Historic England

Pre-application Advice

NEW PLACE FARM, 200 ARUNDEL ROAD, ANGMERING, WEST SUSSEX

PLAN & ELEVATIONS PROPOSED

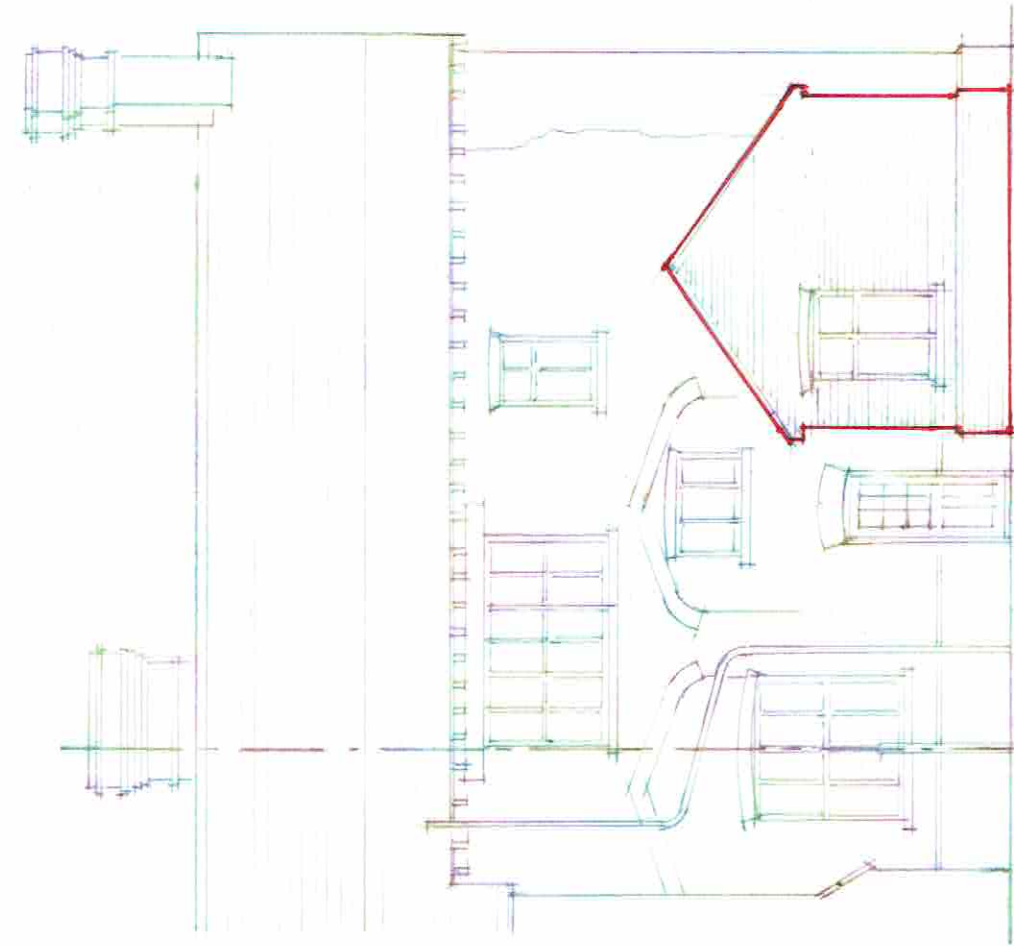
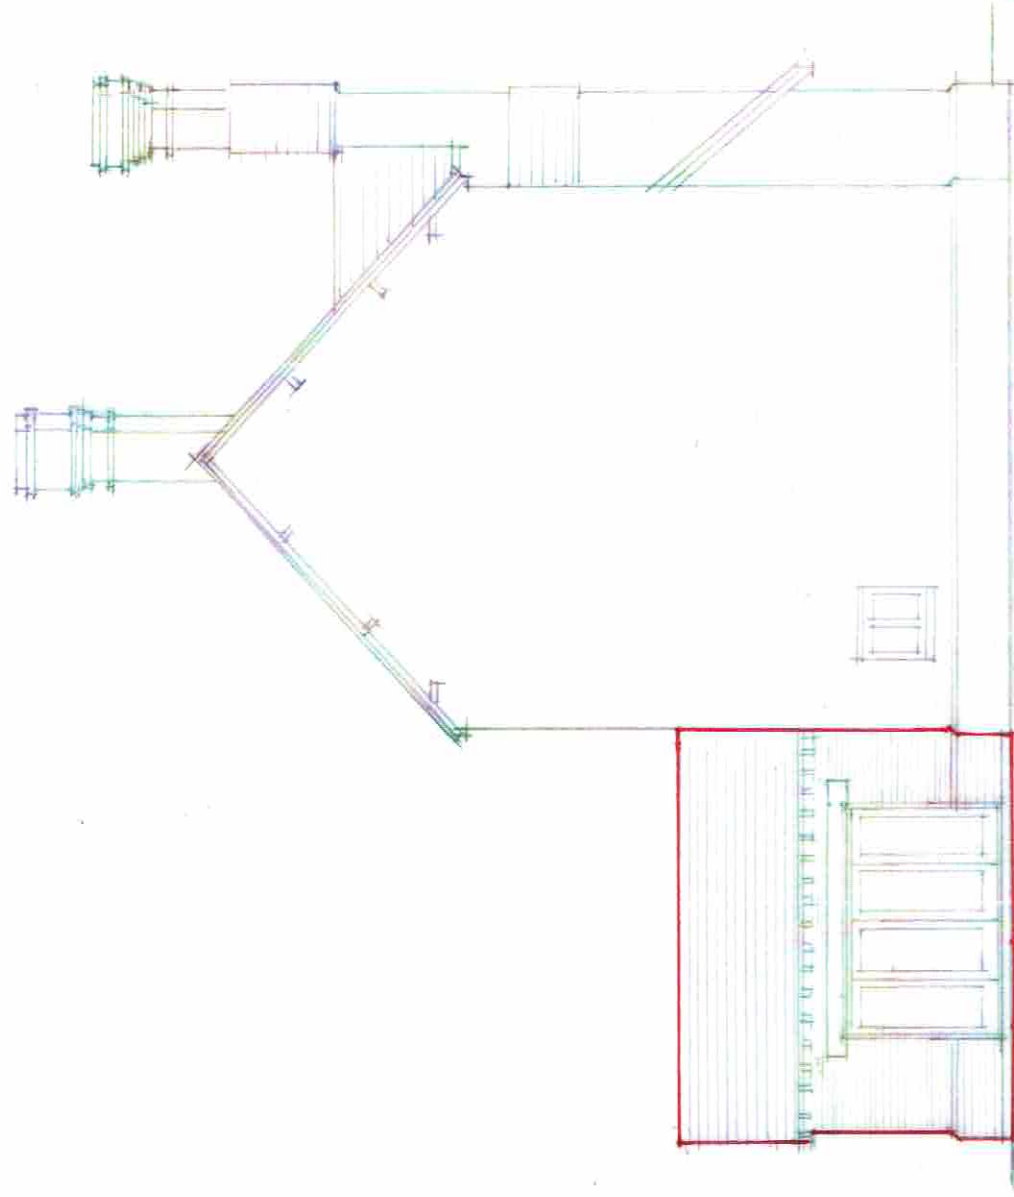
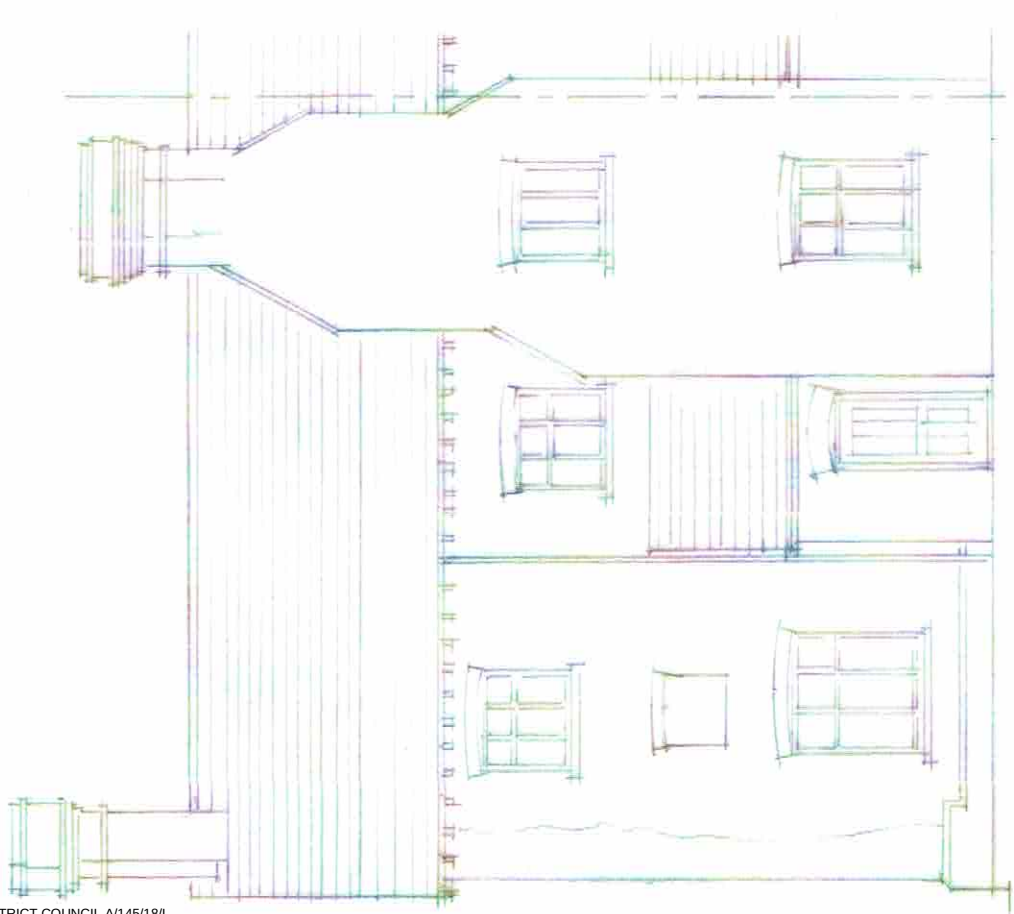
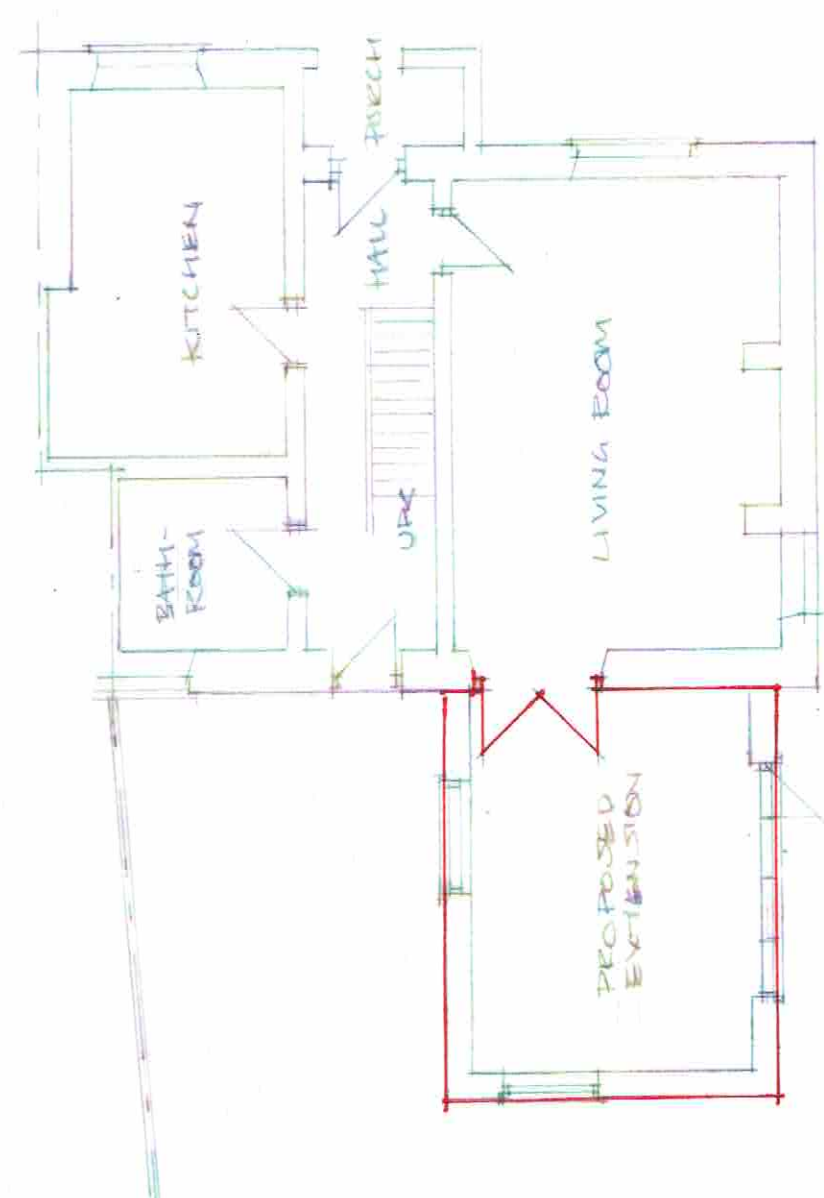
We raise no objection in principle to the addition of a rear extension. To ensure that the new extension is not visible from the front of the listed building, it should be stepped back from the building's side wall as is currently detailed. This will retain a sense of the principal building's form, whilst ensuring that the extension is subservient. Breaking through the rear window opening will see minimal loss of original brickwork and, in planning terms, is the least harmful way of providing a new opening.

That being said, careful consideration will need to be given to the design of the new element. Any new addition should respond contextually to the principal building's consistent use of materials (brick, Horsham stone and clay roof tiles) as well as its regular form. In this way, we suggest that an overly ornate conservatory is likely to jar with this established character and simple form, and will therefore be harmful to the building's significance. For this reason we recommend that a roof lantern and glazed link is not appropriate in this instance.

We feel that the design could be improved by taking references from the main house's consistent and established use of brick and clay tiles, and simple rectilinear and solid form. Similarly, the new addition should be attached directly to the principal building. One design solution might be the use of a tiled gable roof with the extension

incorporating a lower brick plinth.
